**PLANNING ACT 2008
APPLICATION BY HIGHWAYS ENGLAND FOR AN ORDER GRANTING
DEVELOPMENT CONSENT FOR THE A303 SPARKFORD TO ILCHESTER
DUALLING
SUBMISSION MADE PURSUANT TO DEADLINE 4**

PLANNING INSPECTORATE REFERENCE TR010036

Deadline 4 – Somerset County Council - Written Submission of Oral Case made at Issue Specific and Compulsory Acquisition Hearings (26th February – 1st March)

Drawing Number
HE551507 - MMSJV - LSI -
 000 - DR - UU - 2041
 Project Ref. No.
389107
 Revision
C03

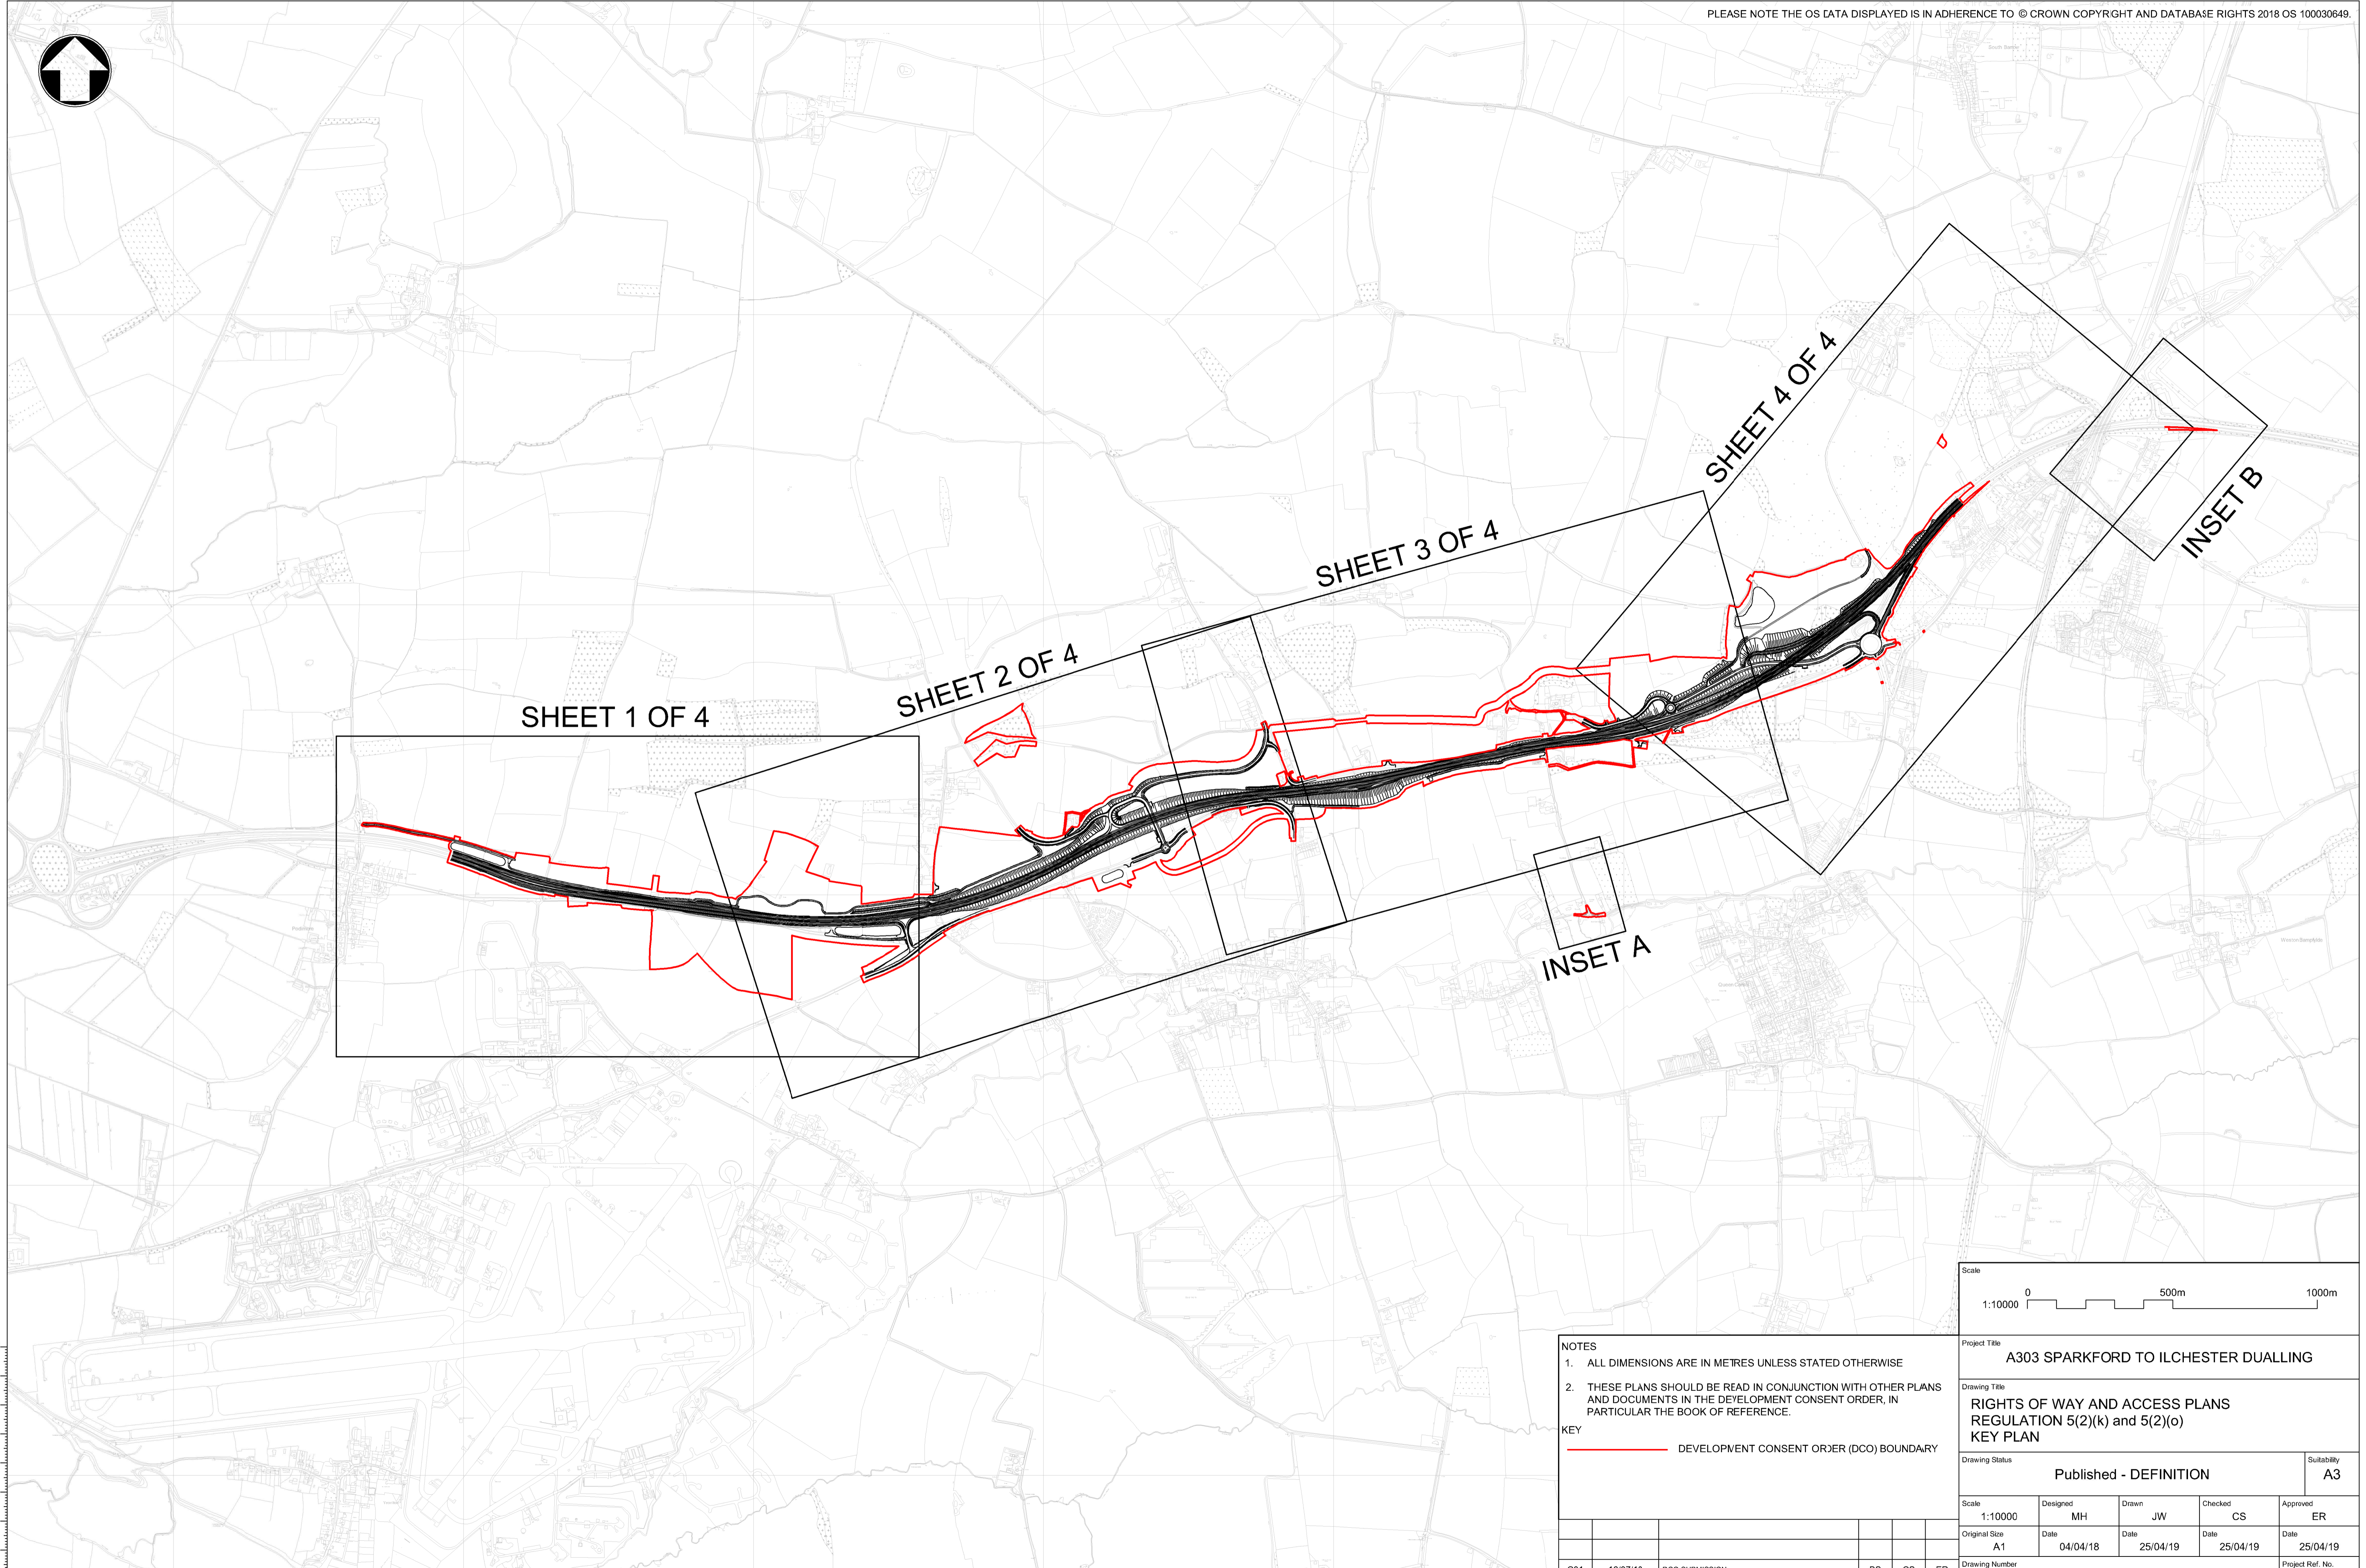
P4	<p>Stopping up of bridleway Y 30/28 and lack of upgrade to Y 30/31 (Ref. .1 Draft DCO Schedule 4 Part 1 & Sheet 1 of Rights of Way & Access Plans)</p> <p>The impact of the development is to stop up the connection of Y 30/28 with the A303 and therefore the applicant has to mitigate for that loss. The current proposal from the applicant is provision of a route east to the nearest new vehicular overbridge. The proposed development creates an adverse effect on this section of Public Right of Way.</p> <p>The applicant, in line with the National Policy Statement for National Networks, is expected to take appropriate mitigation measures to address adverse effects on public rights of way. The County Council considers that the proposed mitigation, whilst beneficial to the overall network is not the most appropriate. The length of the alternative route proposed is c.5.2km for walkers, cyclist and equestrians. If instead the alternative was over Y 30/31, this length would be reduced to c.1.5km. This is a considerable difference in length and convenience. This is not asking for a new over/underbridge, but for improvement to an existing Highways England structure.</p> <p>The County Council does recognise that compared to the usability of the existing bridleway network joining the A303, the proposed scheme should represent a more accessible network, however it is contended that more appropriate mitigation could be provided. National Planning Policy Statement for National Networks is clear that applicants are expected to take appropriate mitigation measures to address adverse effects on Public Rights of Way. Chapter 12 of the Environmental Statement refers to increases in journey length of over 500m results in a Major Adverse impact. At</p>	A connecting bridleway to, and the upgrading of public footpath Y 30/31 to bridleway status would be viewed by the Council as necessary; directly related to the development; and, fairly related in scale and kind for the loss of the Y 30/28 terminus. A planning obligation would secure this.	Obligation	<p>1.3.39 The Applicant has fully assessed the potential impacts of the proposed scheme and the findings of this assessment are set out in the ES that was submitted with the application. The ES did not identify that any of the above mitigation was required in order to make the potential impacts of the scheme acceptable. Therefore, the Applicant considers that the above measures are not required and will not be provided as part of the scheme subject to the DCO application.</p> <p>1.3.41 It has been suggested that the Applicant could use Highways England's designated funds programme to provide the above measures. Designated funds "allow for actions beyond business as usual" and comprise "a series of ring fenced funds designated to Highways England to address a range of issues beyond the traditional focus of road investment"2. The Road Investment Strategy (RIS) identifies areas where Highways England can deliver environmental improvements using such funds.</p> <p>1.3.42 The Applicant has considered the above proposals and, where the proposals are thought to be appropriate, whether</p>	See SCC response to the applicant's Topic Paper: - 9.14 Right of Way Y30-28 (Eastmead Lane); submitted at Deadline 4.

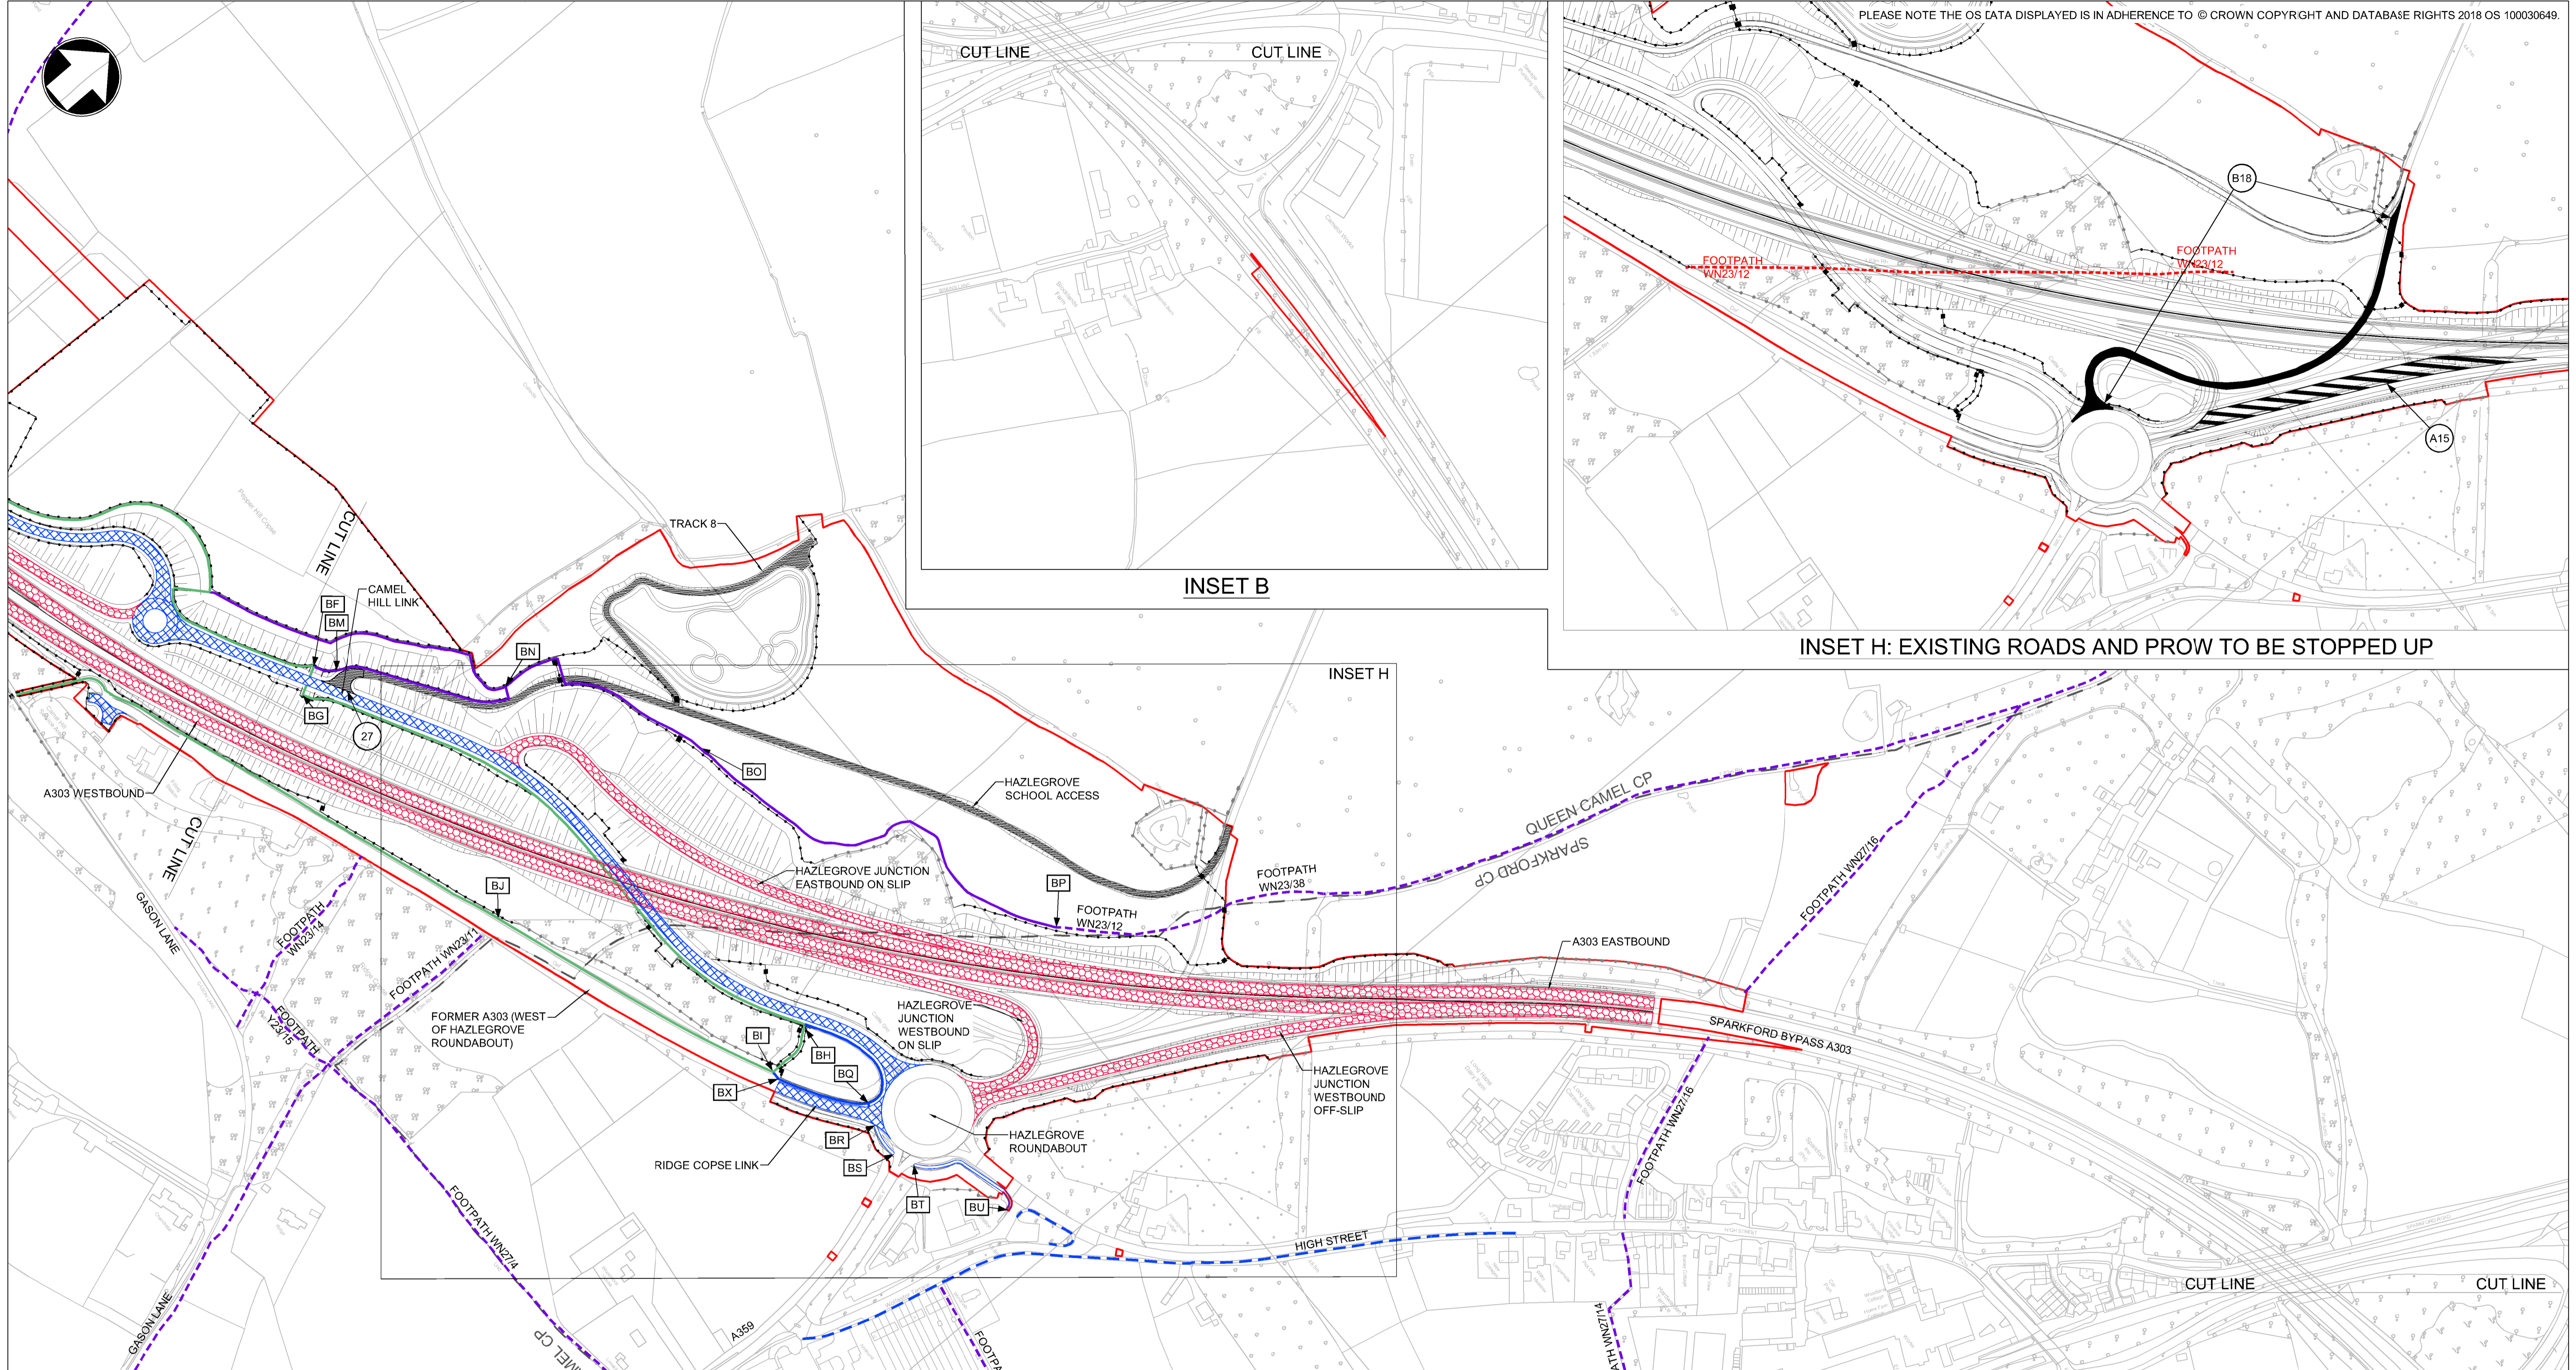
P8	Clarification of routes proposed between Traits Lane and Gason Lane (Sheet 3 of Rights of Way & Access Plans) There are 2 routes proposed between Traits Lane and Gason Lane. This is considered excessive and it is assumed that only one route will be selected, however clarification of such is required	Amendment to Sheet 3 Rights of Way & Access Plans required. Also see issue P16.	N/A	1.13.5 The Applicant's preferred route for this RoW is AZ-BA-BB. This passes through land currently owned by the Ministry of Defence. Discussions regarding the dedication of this right across this land were only concluded recently (see the first item in Table 2.1 of the draft Statement of Common Ground between Highways England and the Defence Infrastructure Organisation (APP-161). Until a written agreement is in place the alternative will remain, although the preferred option is for the RoW to pass through the Ministry of Defence site. This alternative is BZ-CA-CB-CD.	Noted.
